I write to formally add to my objection for the Application Ref: 2025/60/93572/E for the outline development of up to 123 dwellings at Upper Cumberworth (all matters reserved except access).

Having reviewed the submitted layout alongside the annotated plan, I wish to raise the following detailed concerns.

site area 5.53ha / 13.67 acres
 capacity 123 dwellings
 density 22 dwellings / ha
 9 dwellings / acre

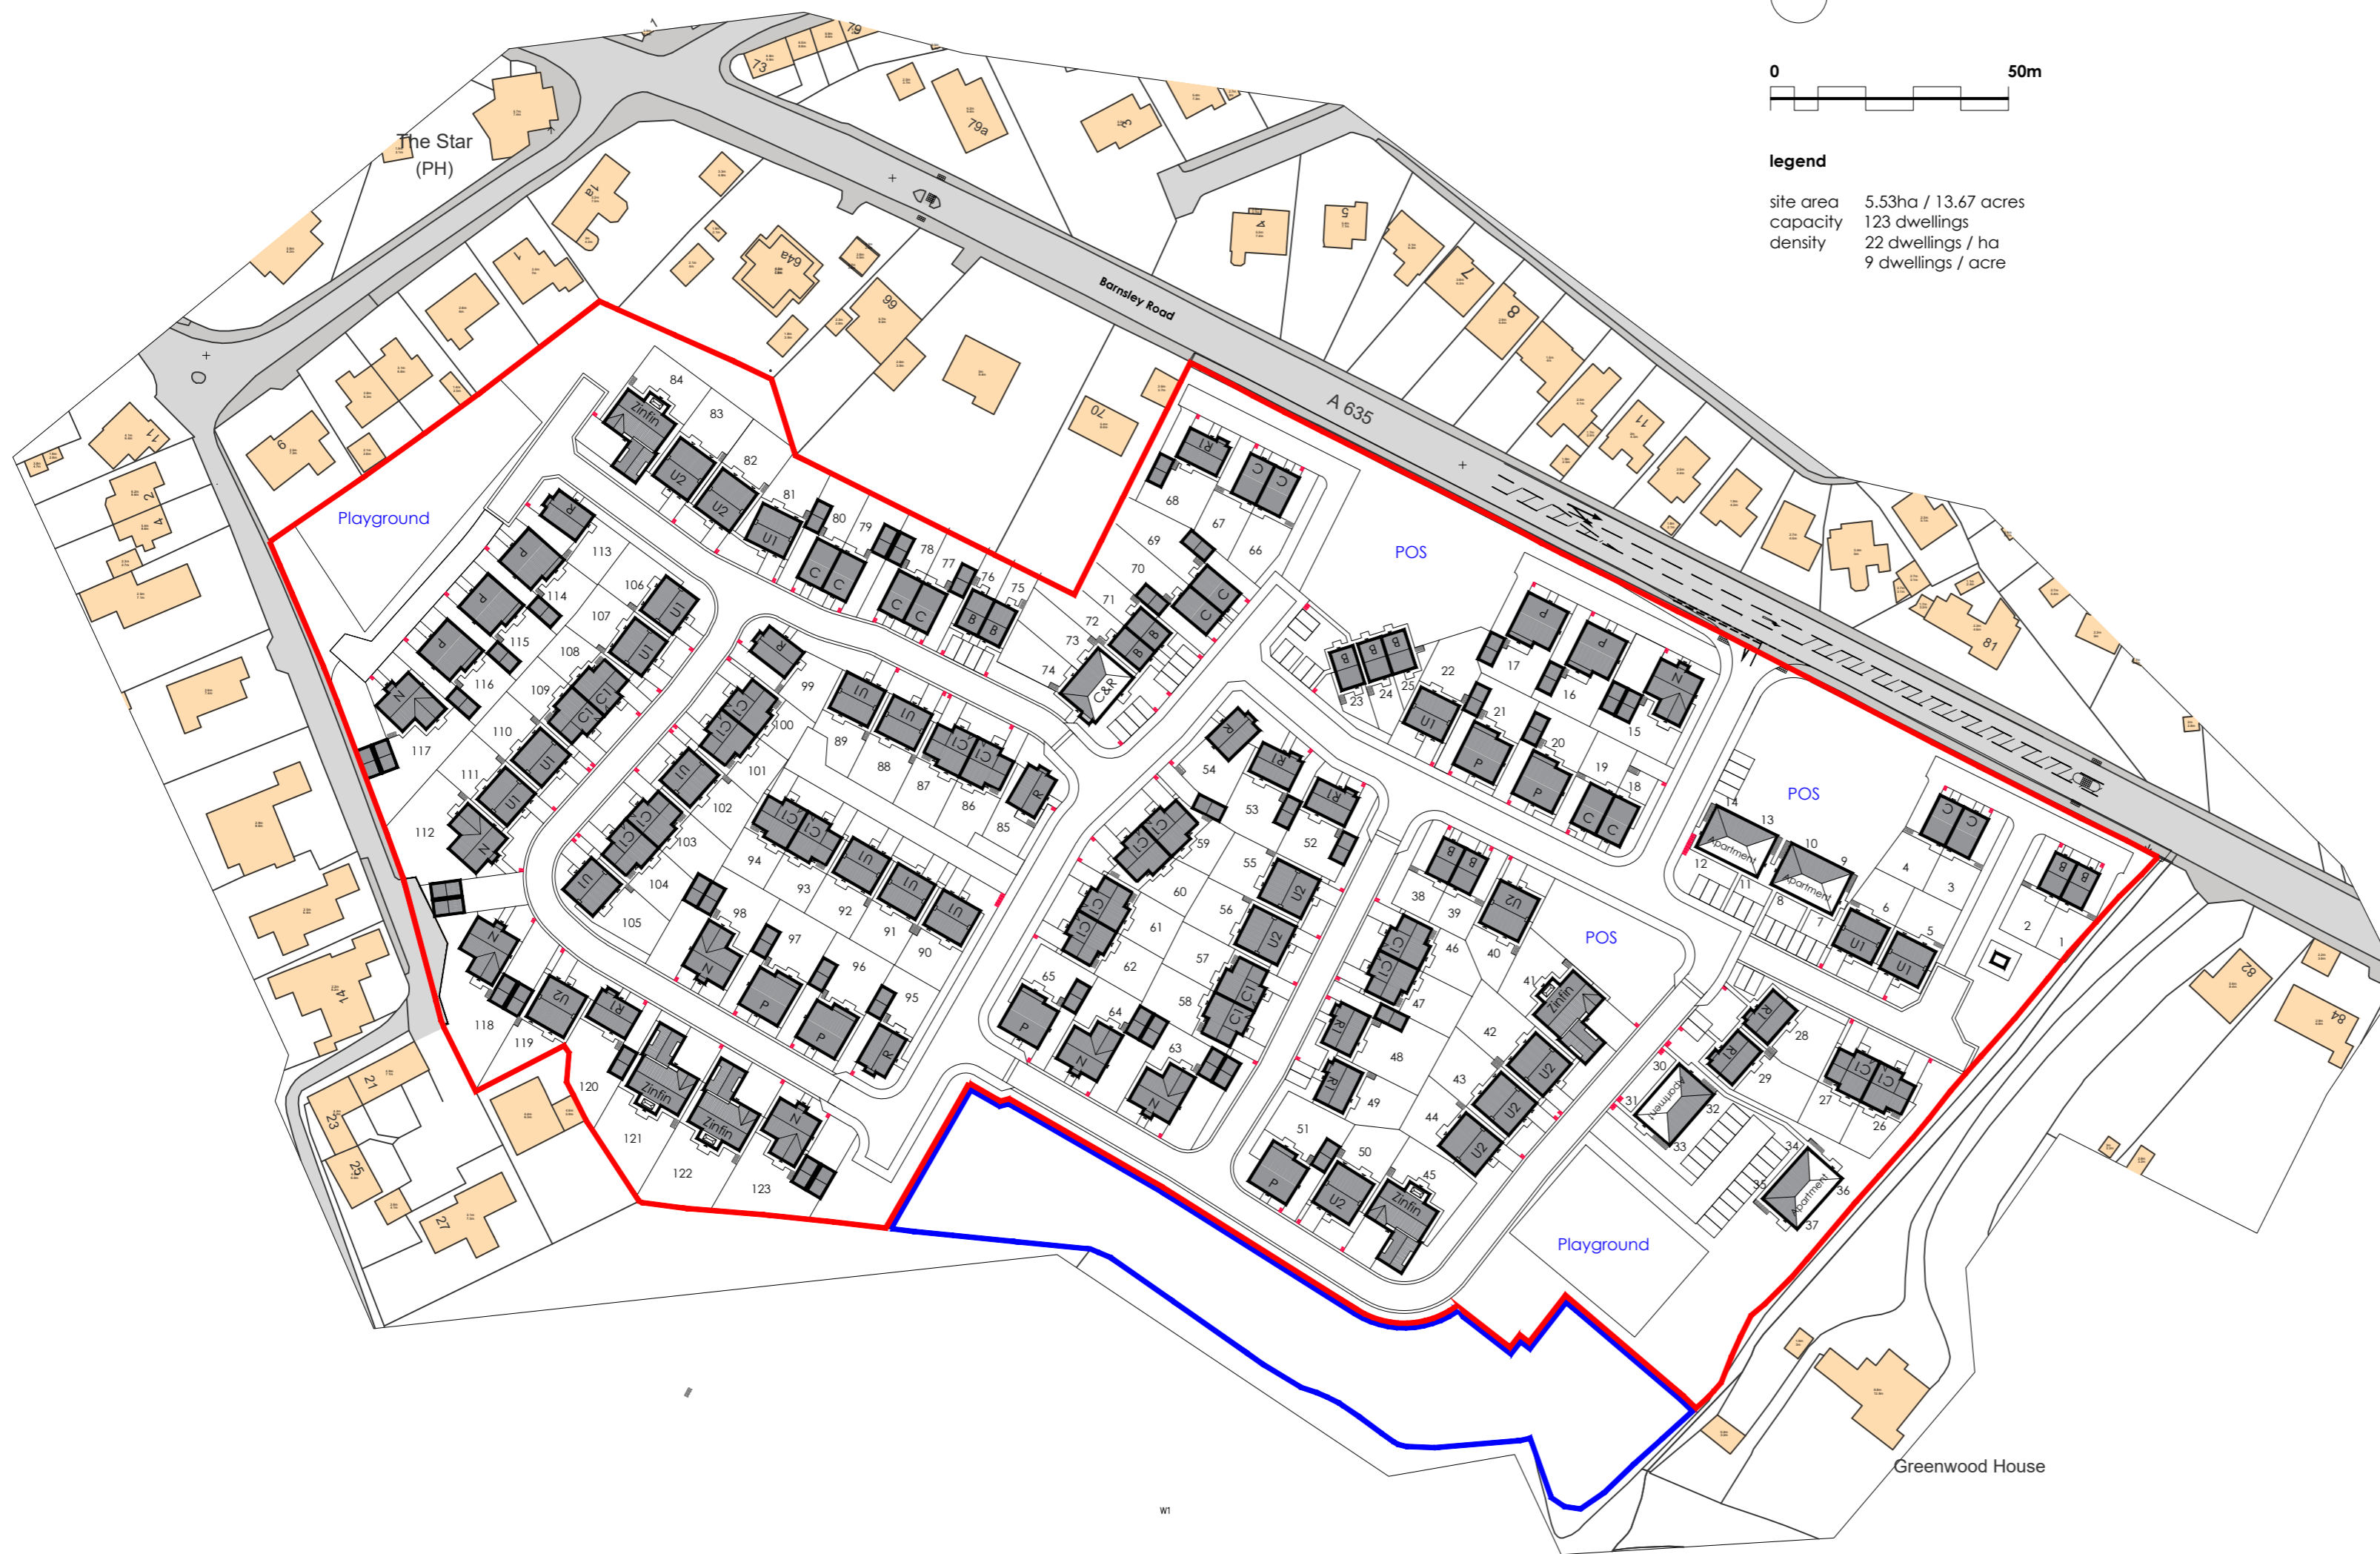
Firstly, the plan clearly shows development parcels encroaching up to, and in places appearing to conflict with, the Green Belt boundary along both the western and eastern edges of the site. This raises serious concerns regarding inappropriate development within the Green Belt and the gradual erosion of its permanence. The quantum of development proposed fundamentally undermines the purpose of safeguarding the countryside from urban sprawl.

The layout also demonstrates insufficient stand-off distances around protected trees. The annotated drawing identifies a "stand-off area surrounding protected trees," yet several plots are positioned extremely close to these areas. Development within root protection zones risks long-term harm through soil compaction, level changes and service installation. This is particularly concerning at outline stage, where the principle of layout density is being established.

Several plots are marked as "too close to boundary." These relationships suggest inadequate separation distances between new dwellings and existing site edges or neighbouring properties. This would likely result in overlooking, loss of privacy, overbearing impacts and a development form that does not respect the established grain of Upper Cumberworth.

The plan identifies a historic field boundary which is intended to remain. However, the indicative layout shows development pressing up against this feature, eroding its landscape setting. Historic field patterns are an important part of the village's agricultural heritage and should be retained with meaningful buffers, not reduced to token remnants within a housing estate.

Multiple areas on the plan are labelled "inappropriate design." The estate-style configuration, cul-de-sac arrangements and density appear suburban in character and out of keeping with the organic, lower-density rural form of Upper Cumberworth. Even at outline stage, the number of dwellings (up to 123) dictates a level of density that is inconsistent with the village context.

The yellow shaded area on the annotated plan identifies important long-distance views that should be retained. The proposed development intrudes into these view corridors, particularly along Barnsley Road (A635). These open views contribute significantly to the rural approach and setting of the village. Their erosion would materially harm visual amenity.

The plan also notes that less than 10% Public Open Space (POS) is currently shown. On a site of this sensitivity, particularly one affecting Green Belt land, a significantly higher proportion of open space (at least 25%) would be expected to respect the green environment. The limited provision indicated is wholly inadequate for a development of this scale.

Highway and servicing concerns are also evident. The annotated plan highlights that a turning point is required on Park Lane to allow farm and refuse vehicles to turn safely. The absence of such provision raises highway safety and operational concerns. In addition, no parking is shown for the existing farmhouse, suggesting inadequate consideration of existing land uses and potential future conflict between residential and agricultural activity.

Part of the development is identified as being within the ancient woodland stand-off zone. National policy requires significant buffers between development and ancient woodland. Any encroachment into this buffer risks ecological harm through changes in hydrology, root disturbance and increased recreational pressure.

The annotated drawing also raises serious concerns regarding the red line boundary. It states that the red line should include the buffer area, as this represents a change of use. Furthermore, the drainage

strategy appears to require a land strip to connect to an off-site watercourse, yet this is not properly reflected within the red line. If land outside the application boundary is required to make the drainage strategy work, then the application is incomplete and its deliverability uncertain.

Finally, the development of built form close to Barnsley Road (A635), combined with proposed pedestrian crossings, would introduce an urbanising effect along a currently open rural frontage. This would significantly alter the character of the gateway into Upper Cumberworth.
